**Subject:** Re: OBJECTION :Planning Application 3/2024/0196 Approval of details reserved by

Conditions 9 (surface water sustainable drainage scheme) and 17 (boundary

treatment) of planning permission 3/2019/1104.

With reference to the above planning application Ref (3/2024/0196) I write to offer my **objection** to this application (which is supported by

Drawing Title	1800 Screen & 600 Trellis
Drawing Status	Planning Detail

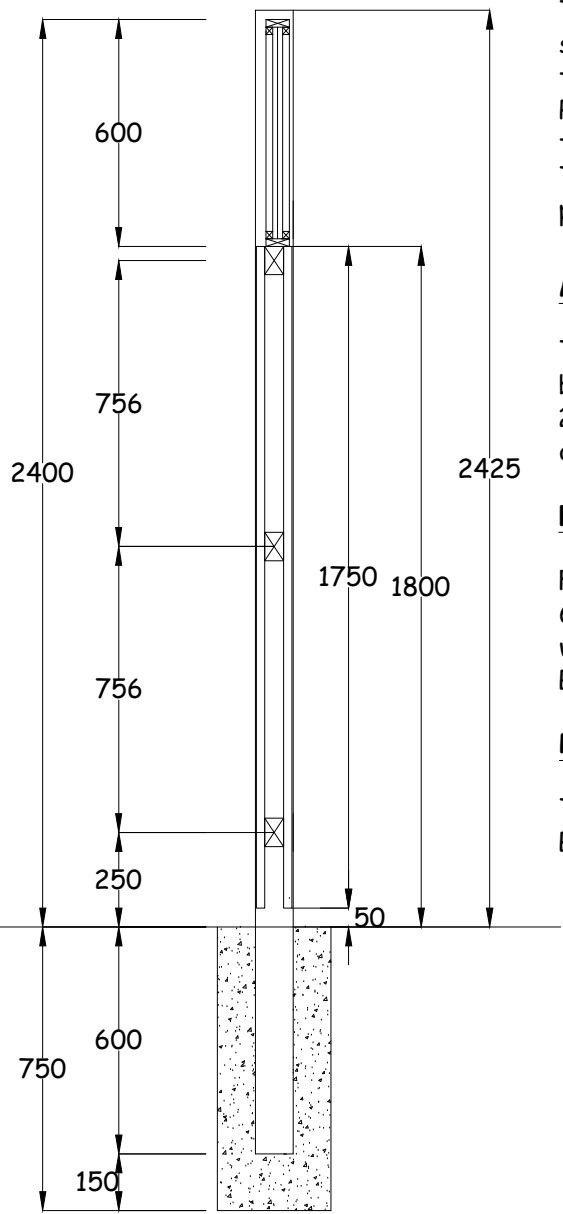
- 2. The boundary treatments were approved previously but now amended due to the new drainage proposal
  - Is this the case?
- 3. The lack of privacy to my property <u>is legal</u> and that the council approved the layout and, height and positioning of the new plots

- Why supposedly are RVBC not replying?
- 4. They accepted that the privacy to my property was very much determined by the height of fence height of my due to the angle of the property

- o Shockingly they asked me to speak to whether they would be comfortable with their fence being higher. Not only is this unacceptable as why should my neighbour have to commit to something they are potentially uncomfortable with for my properties privacy but also should they come to sell then I am left with no guarantees that the new owner wants to change to the fence height, remove any trees etc.

Development	Hawthorne Farm		
Location	Clitheroe		
Marketing Name			
Drawing Title	Sections A-A & B-B & C-C		
Drawing Number	SLF.PL01.6		
Revision	Scale @ A2	1:200	
Drawn By	LA	Date Started	Apr 24
 Persimmon Persimmon Homes (PLC) Phone: 01524 542000

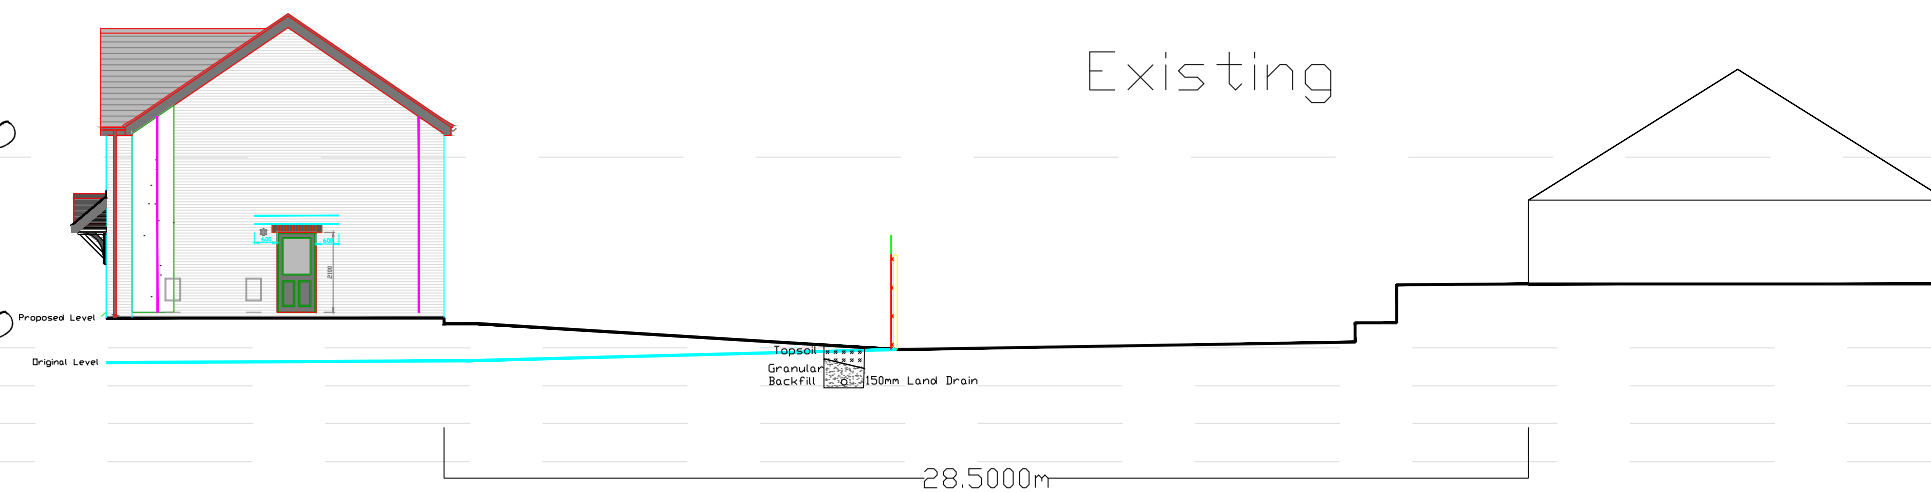
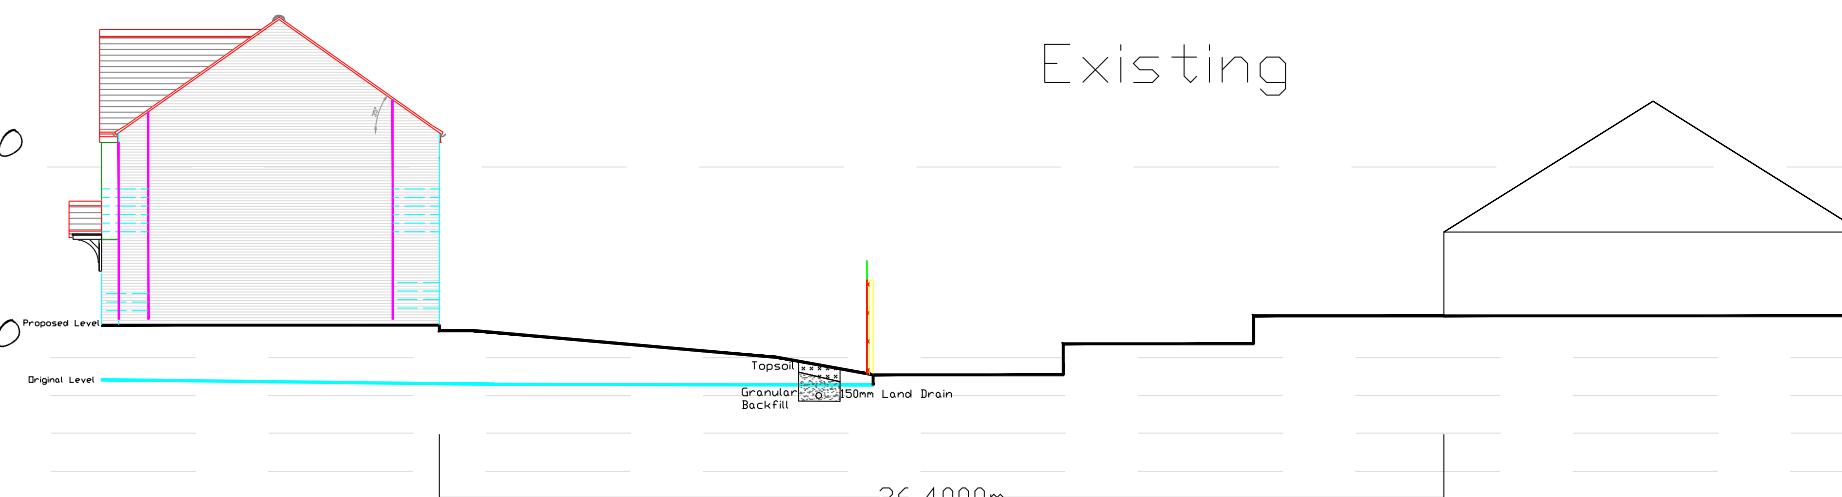
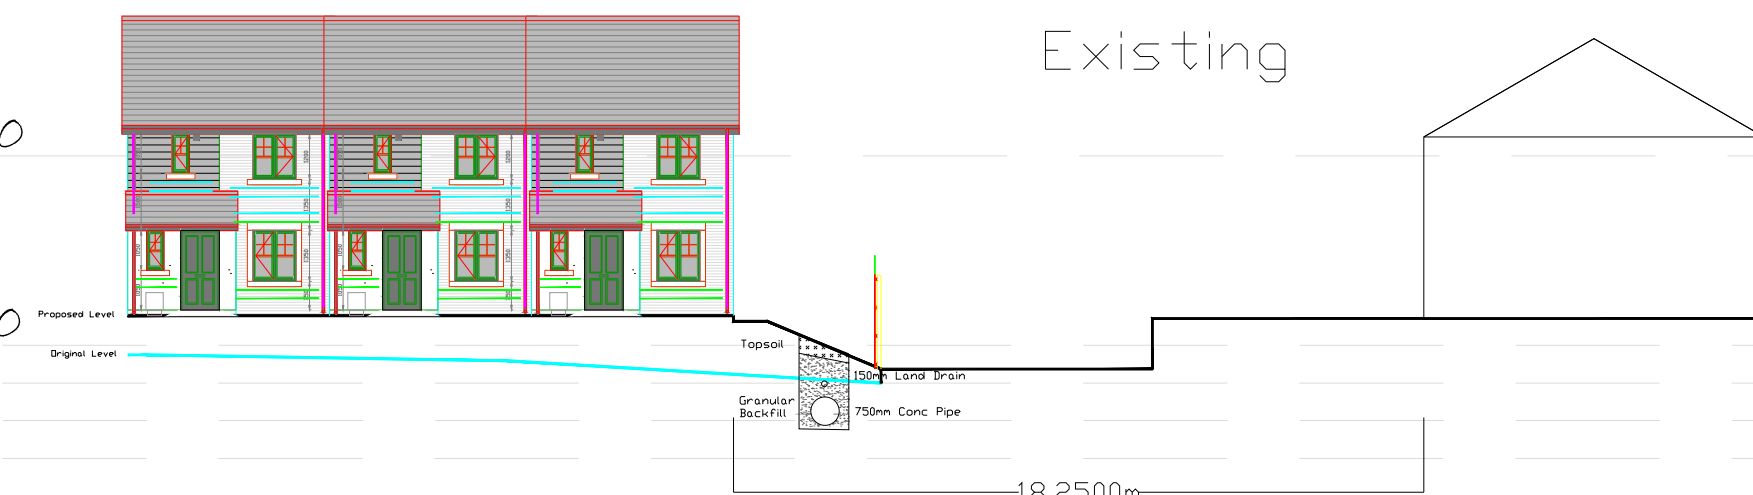
- 1. There is no possibility of the height of the houses being amended
  - When asked why, Persimmon advised the heights were due to drainage That the system would not work with out these heights
    - Is this the case? Why was not this considered during approval of the initial application
  - When asked why can the properties can not be changed (i.e. the direction in which they face) to allow more privacy to my property but maintaining the drainage height requirement Persimmon advised the council had approved the property positions and heights on the initial application
    - Is this the case?

- Is this acceptable?
- 5. Finally with regards to why soil was redistributed around the site rather than taken off (which does appear to be a contributing factor to the overall height of the site)

- Sustainabilty was cited as the reason as to why i.e. cost to remove
    - Has this contributed to the site being higher than actually it should be to original plans?
